SUBMISSION FOR APPLICATION No. SSD6116

Please find the submission below that strongly OBJECTS to the current Development Application SSD6116

Drawing Title
SECTION AA

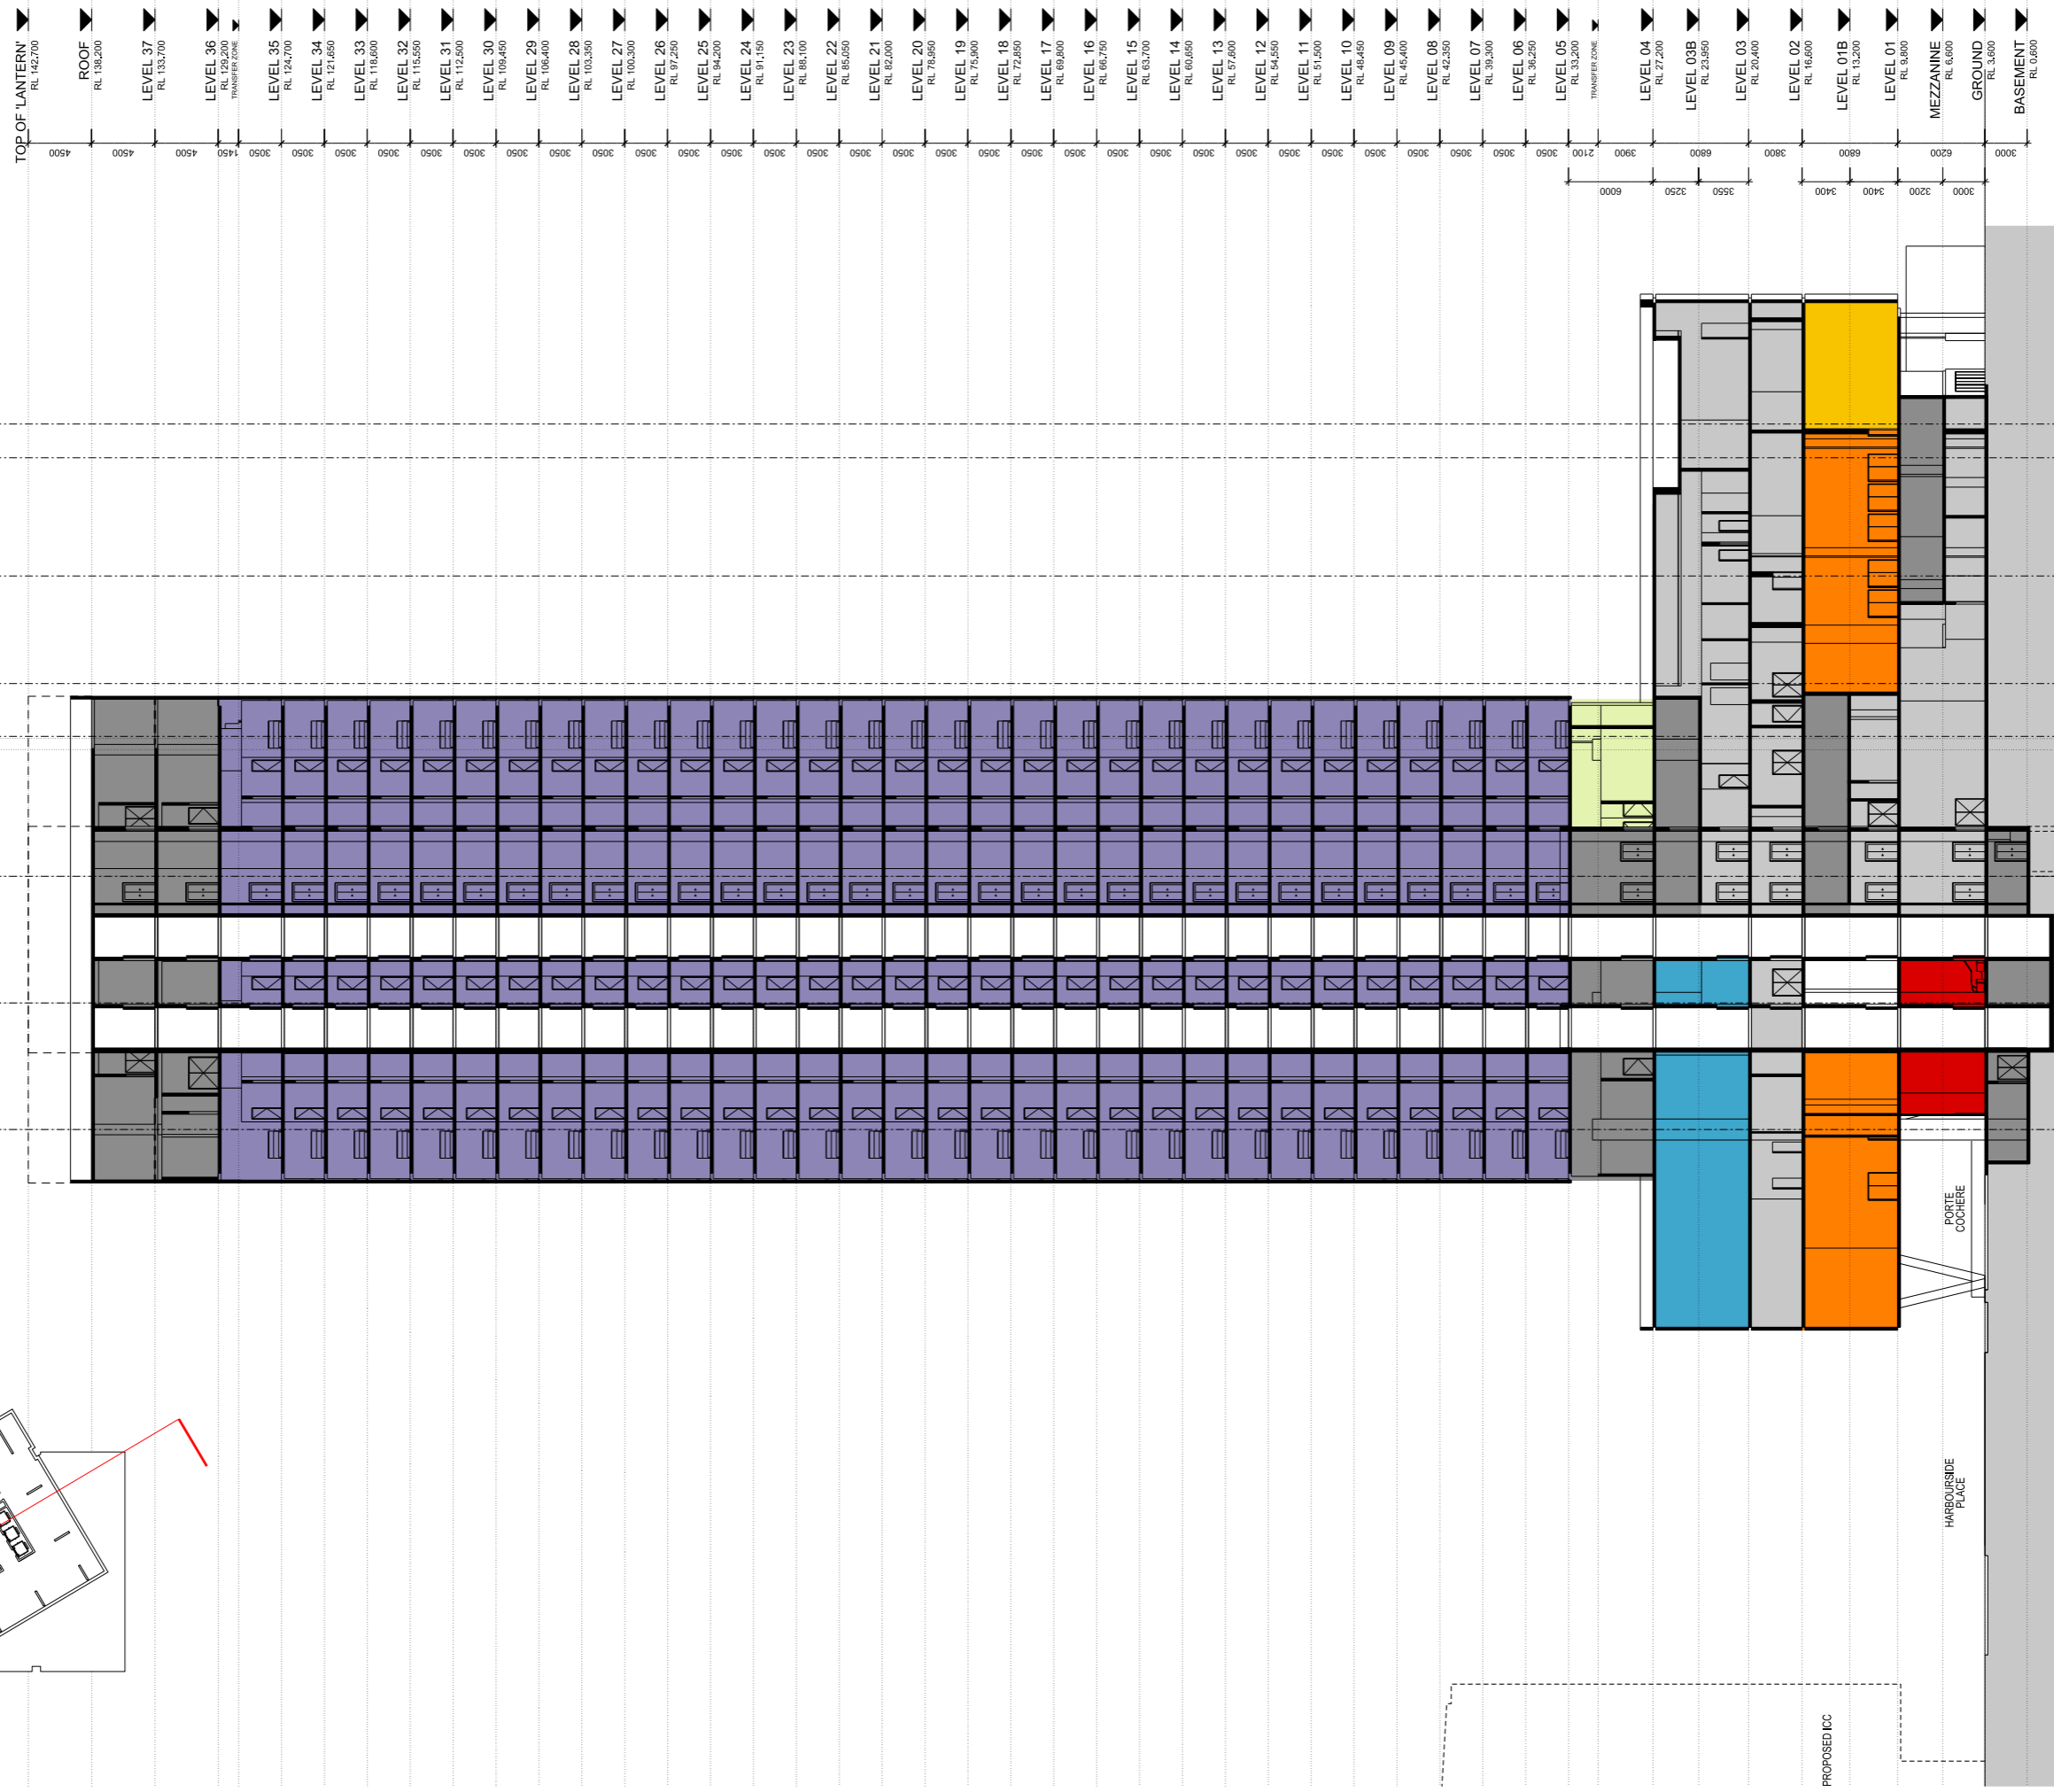
3) The height proposed for this building (38 storeys is against all other buildings in the area and out of place

Notice that the skyline in the photo, the Goldsbrough and the Novotel are in line with each other. The new ICC Hotel is ugly, straight sided, too tall, and in the wrong area.
